Y/31/21/PL

Land East of Drove Lane Yapton BN18 0EB

Temporary sales cabin & associated landscaping. This application may affect the setting of listed buildings

Item 2 - Quantity 5
STATIC BANNER FLAG POLE COMPLETE WITH DOUBLE SIDED FLAG

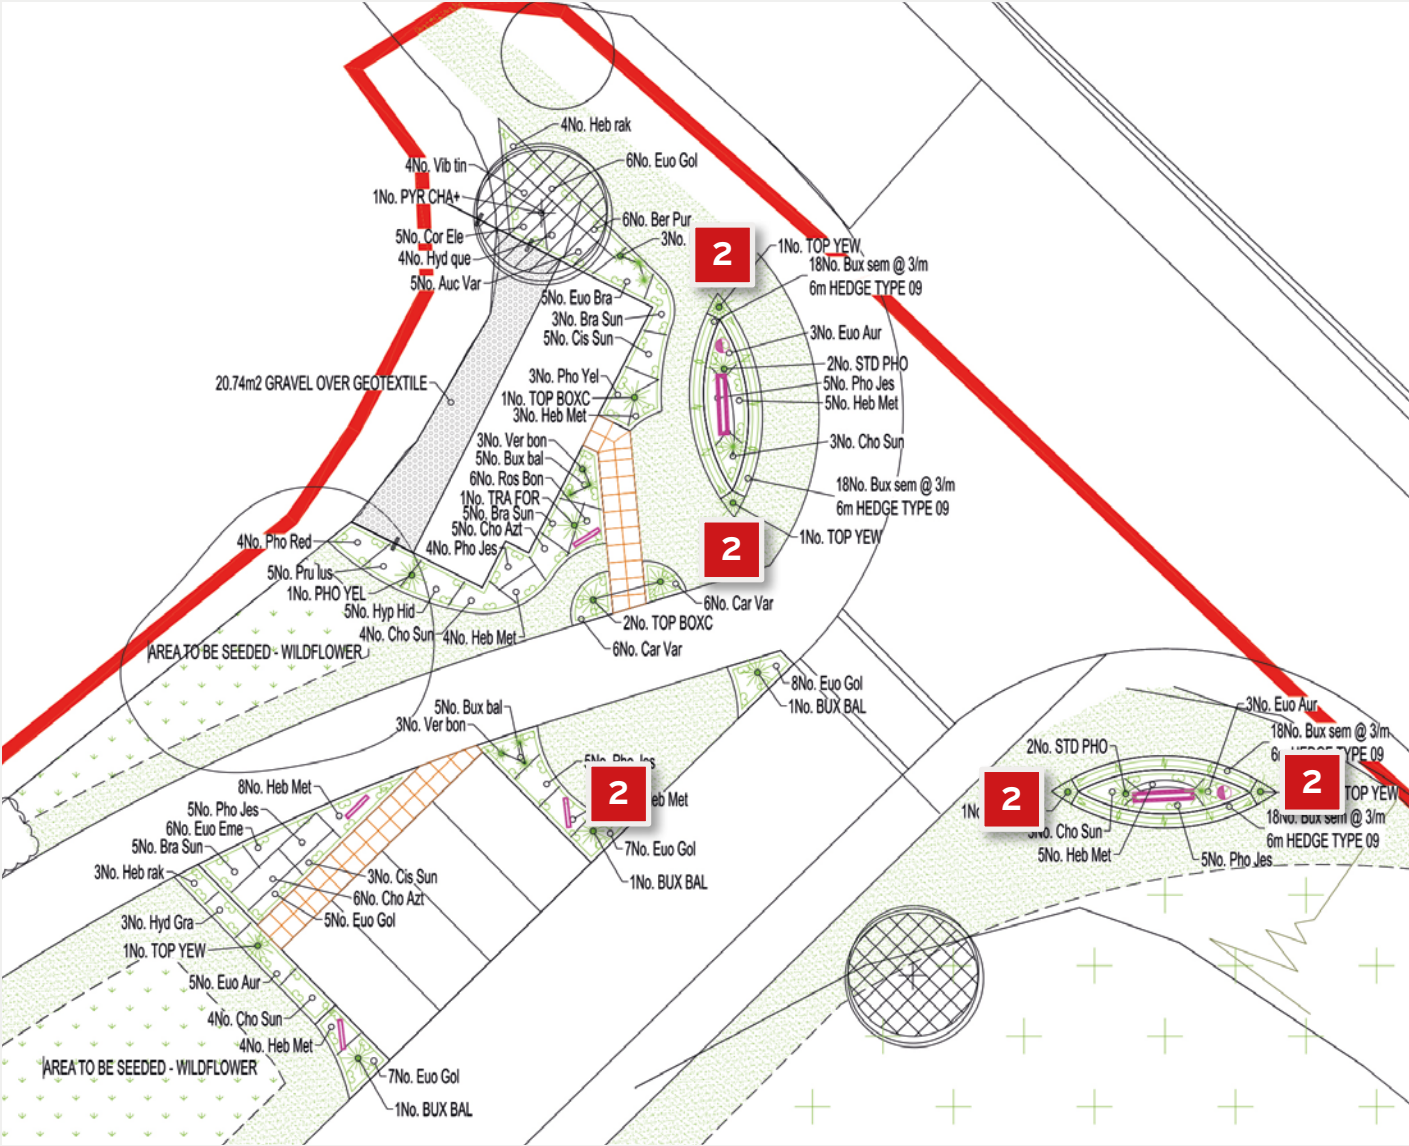
The application includes a number of signs of differing sizes and appearances utilising the logo and colours of the developer. Whilst such signs are normally associated with a development such as this, I am concerned with the size and number of some of them. For instance, the static banner flag stands at just under 5 metres high and will be in five locations, all clearly visible from the

“Premium” Barratt MAIN SIGN TOTEM (DOUBLE SIDED)

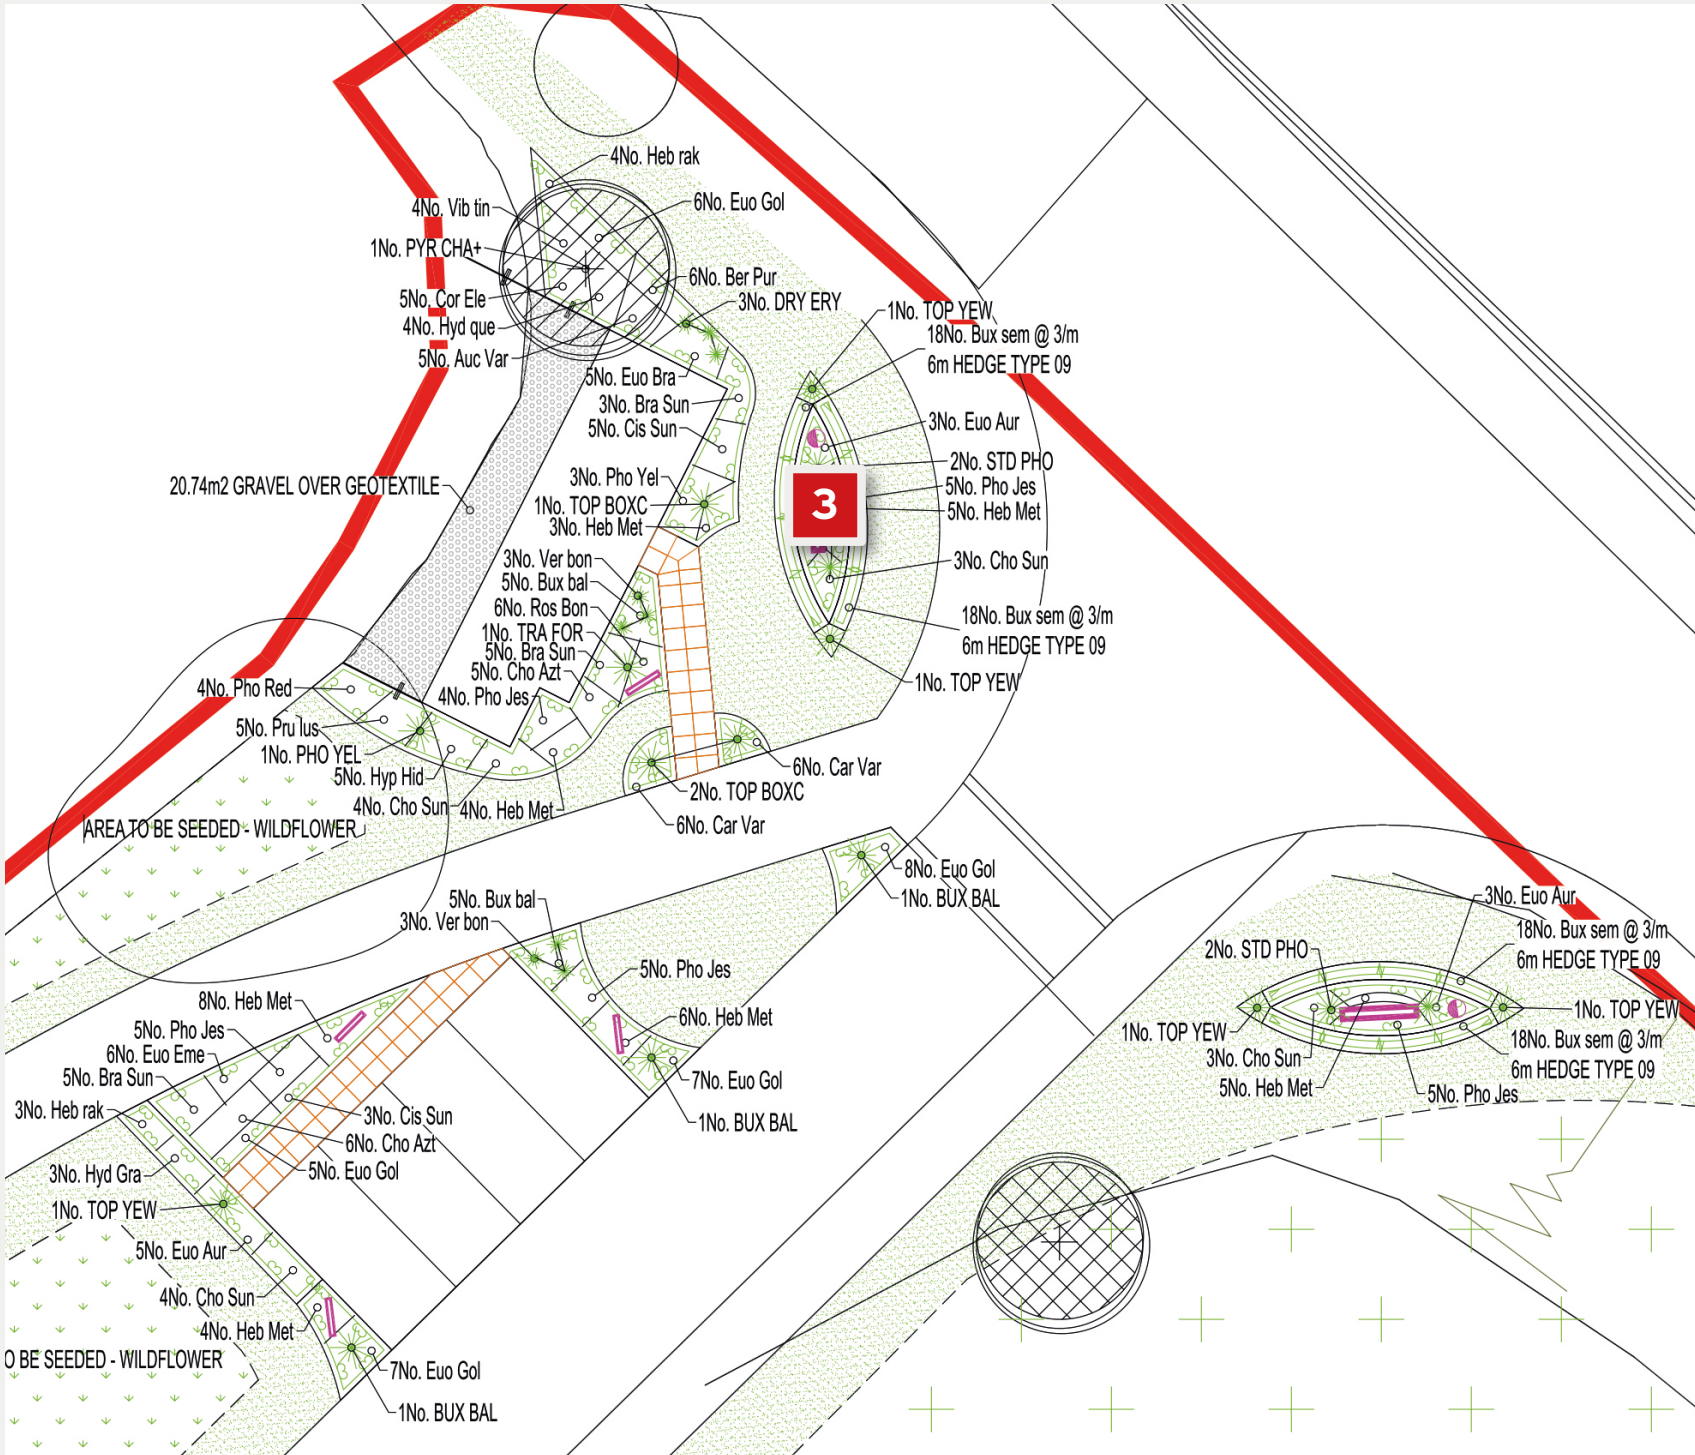
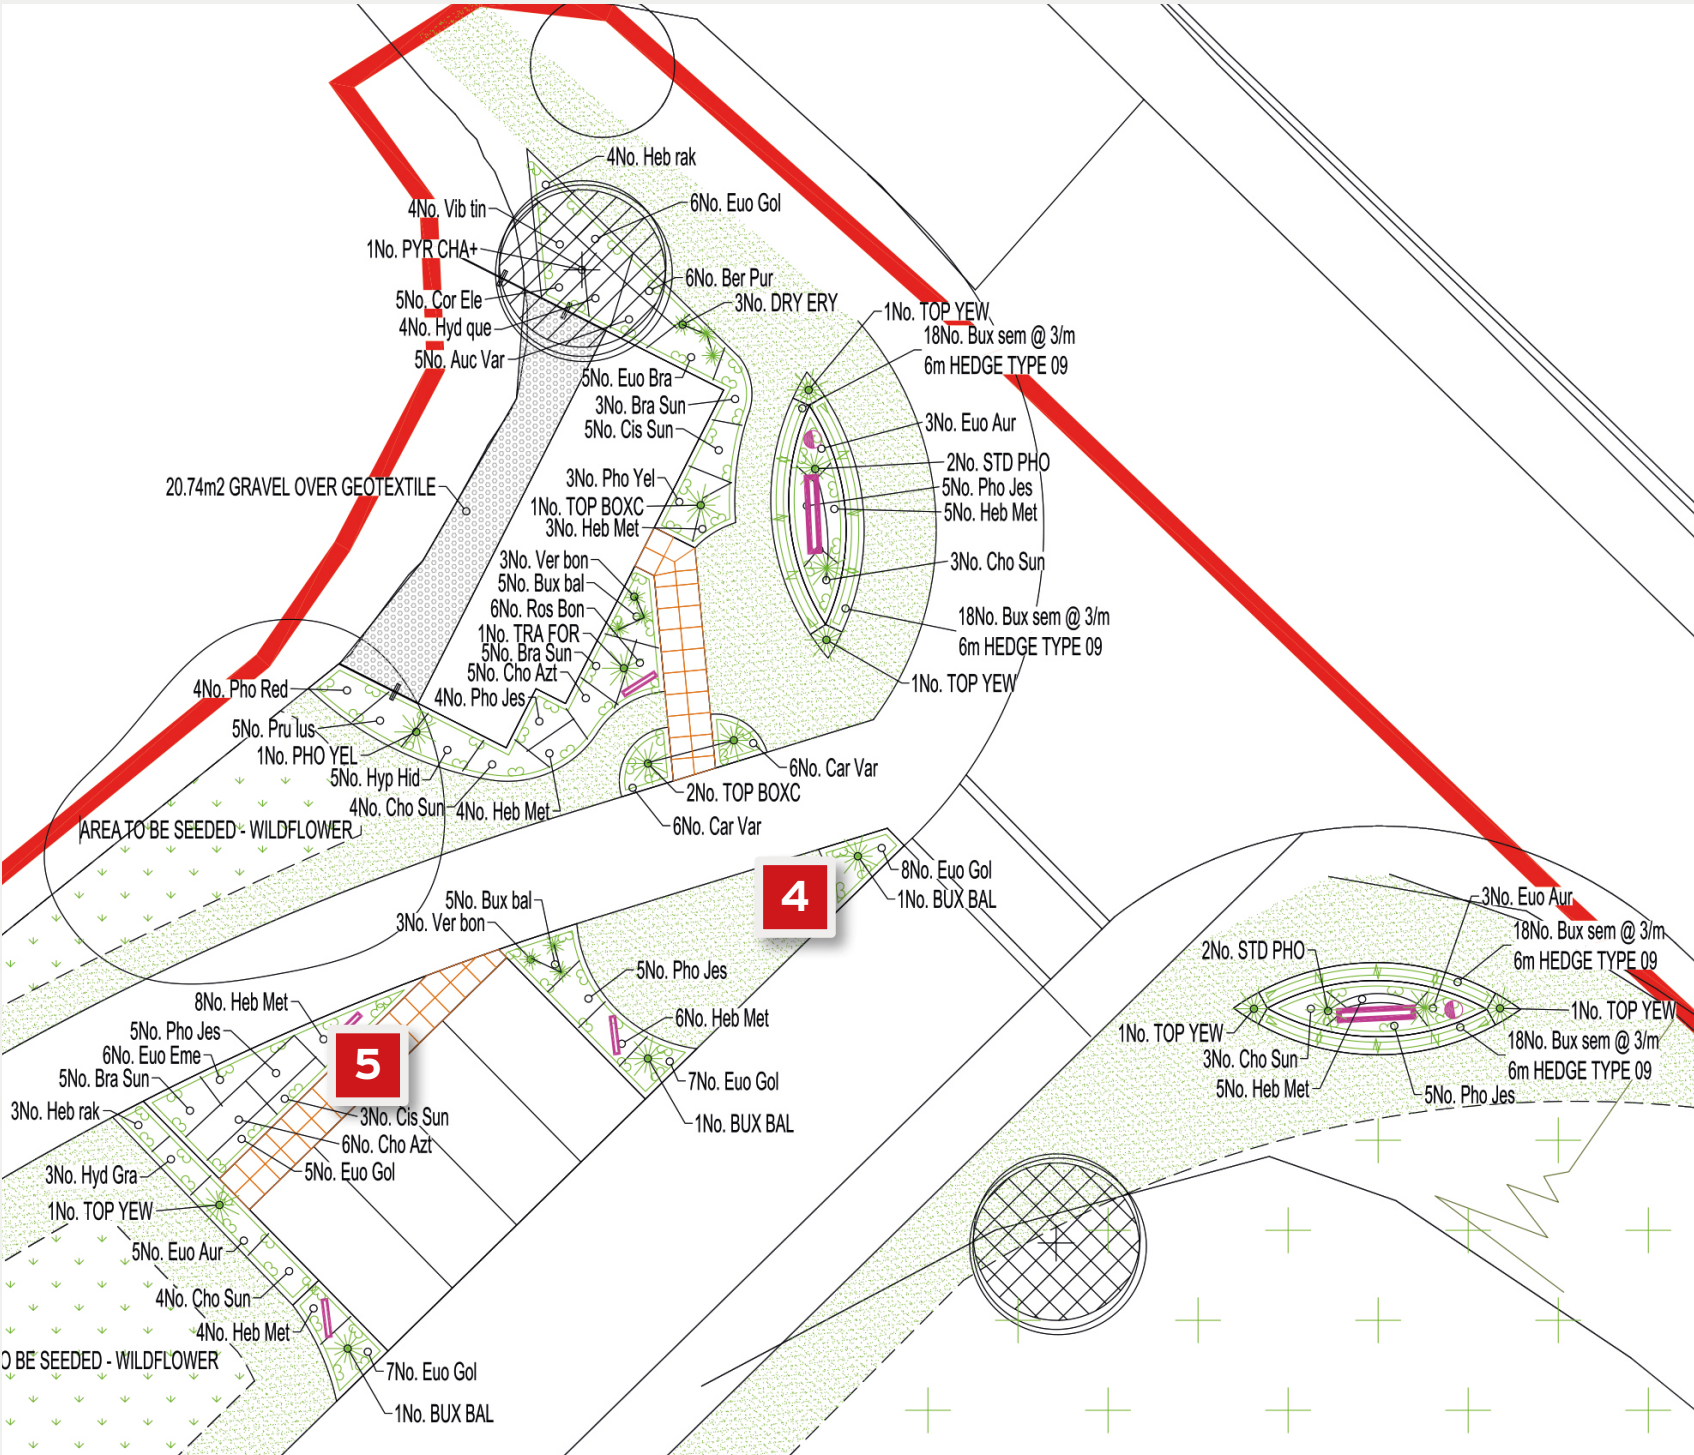
conservation area/listed buildings. Further, there will also be a main totem which would be approximately 4 m high and 1.5m wide. These will be supplemented by a number of other smaller signs.

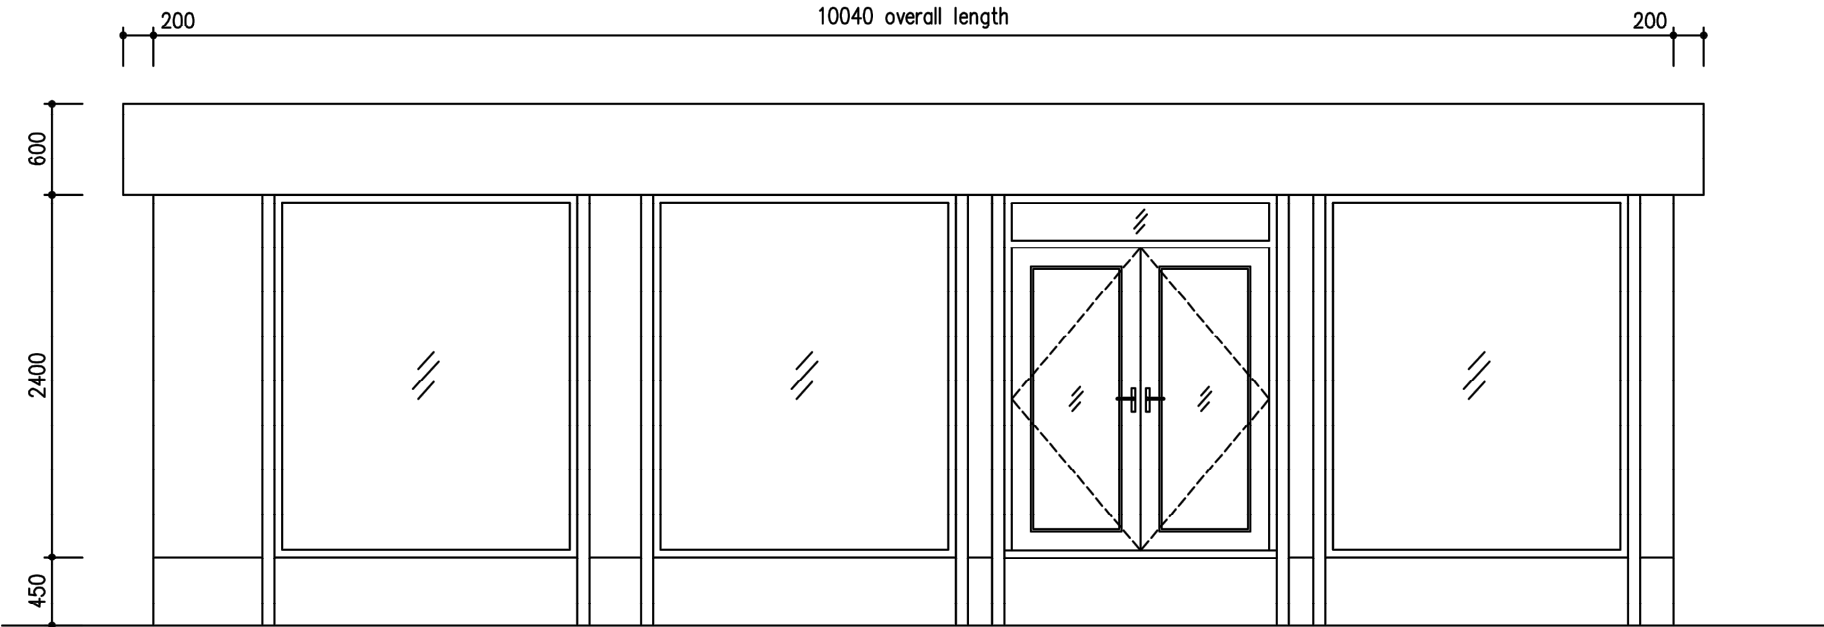
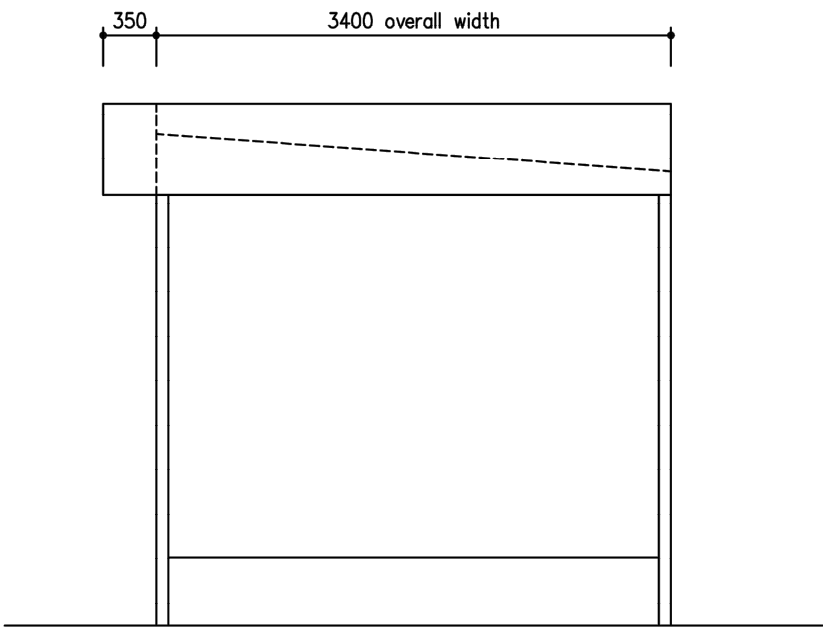
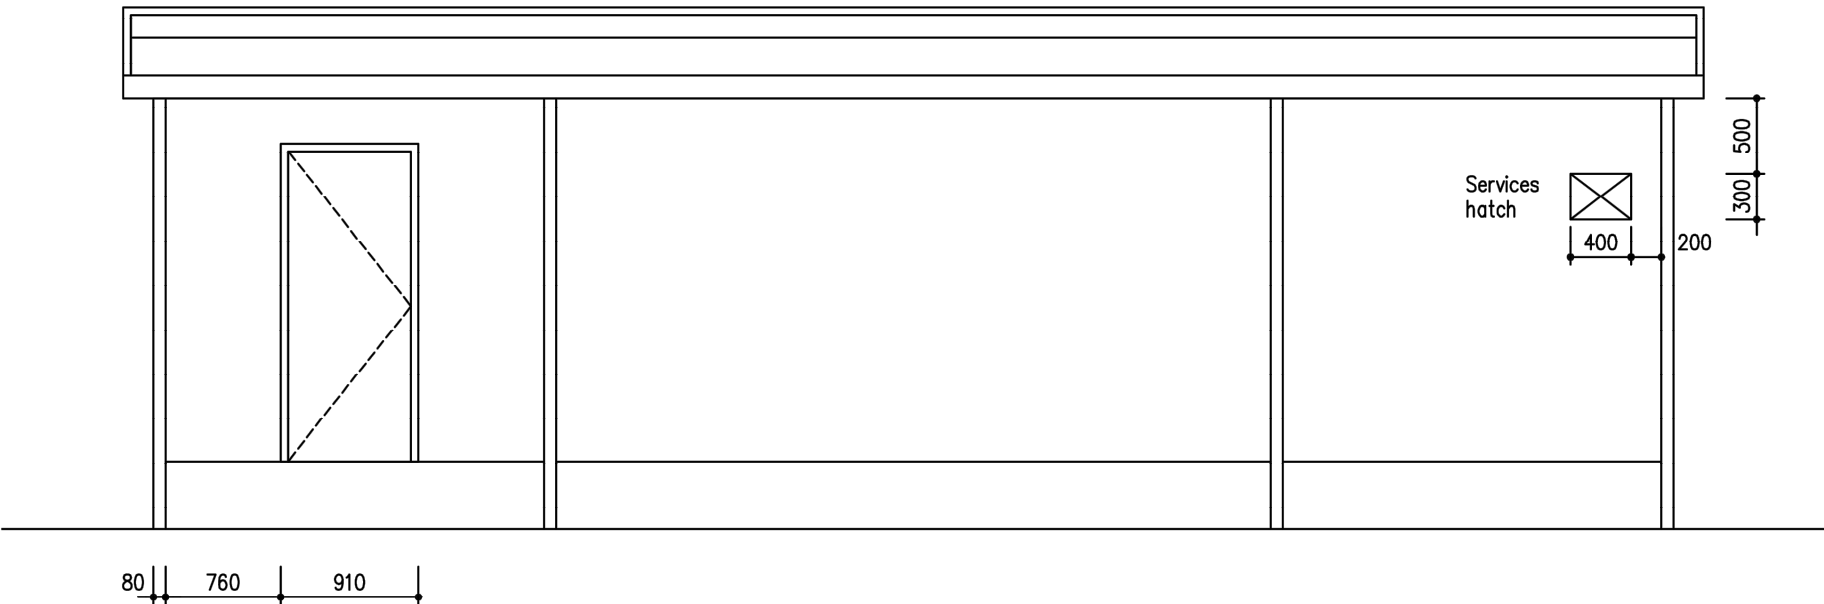
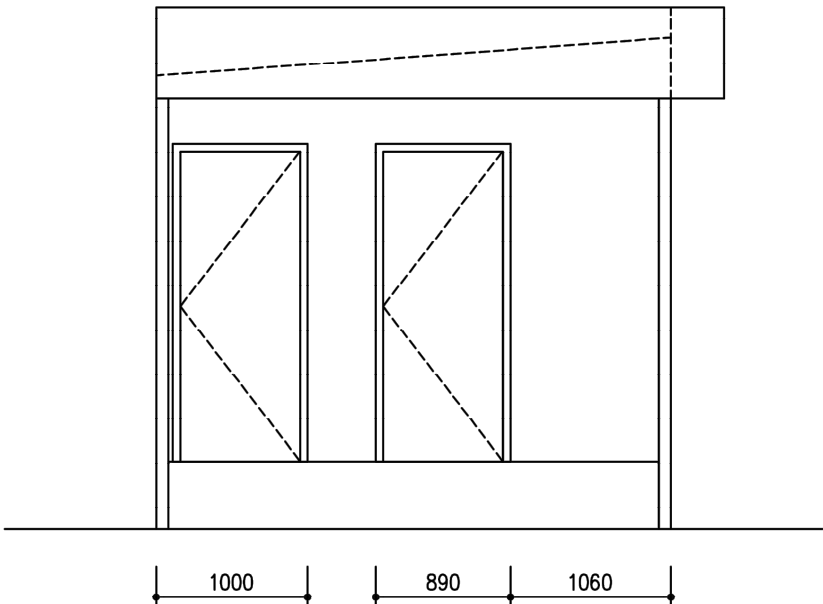
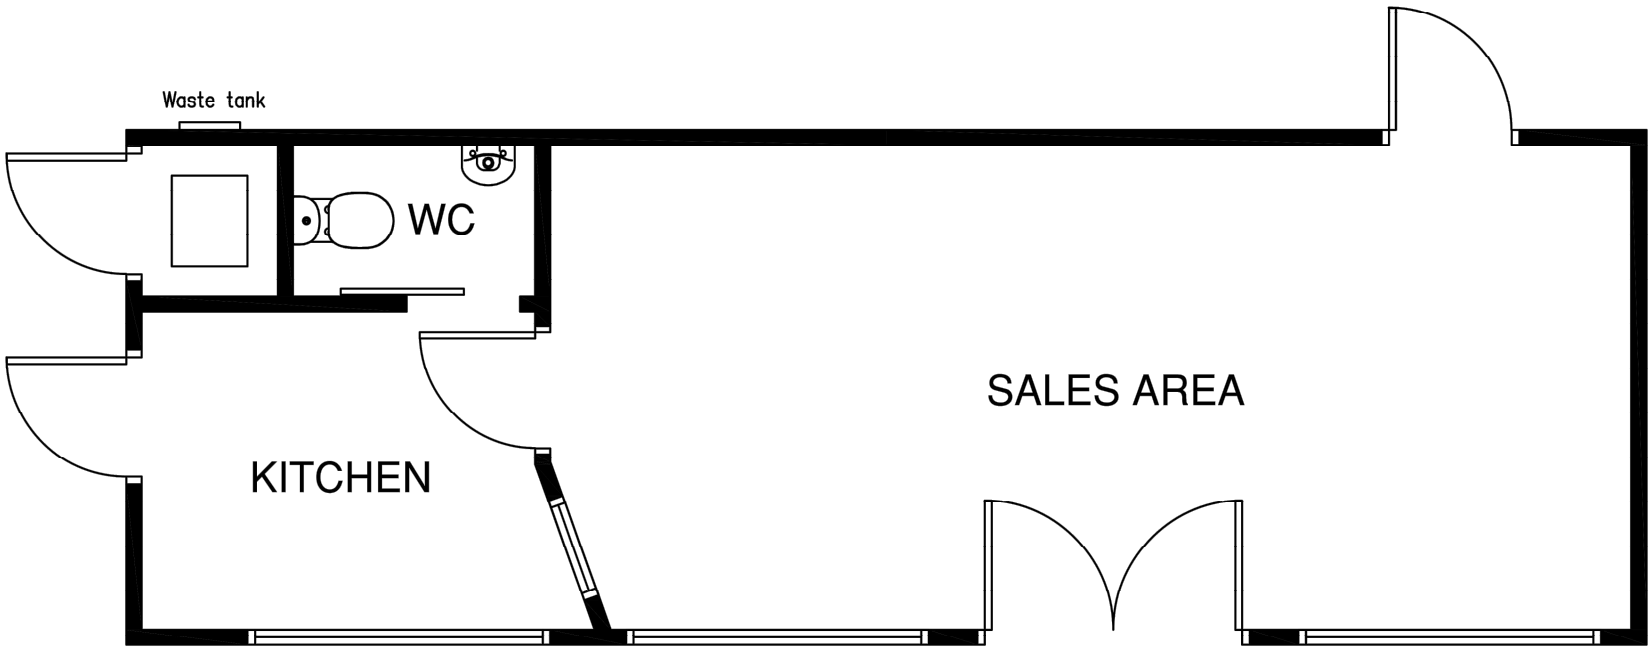
The sales cabin is a fairly simple structure with glazing on the principal elevation and decorative panels on the remaining. It would appear that it is of a standard design used by the company. The plans indicate that it would be located adjoining the new point of access for the development and alongside Main Road.
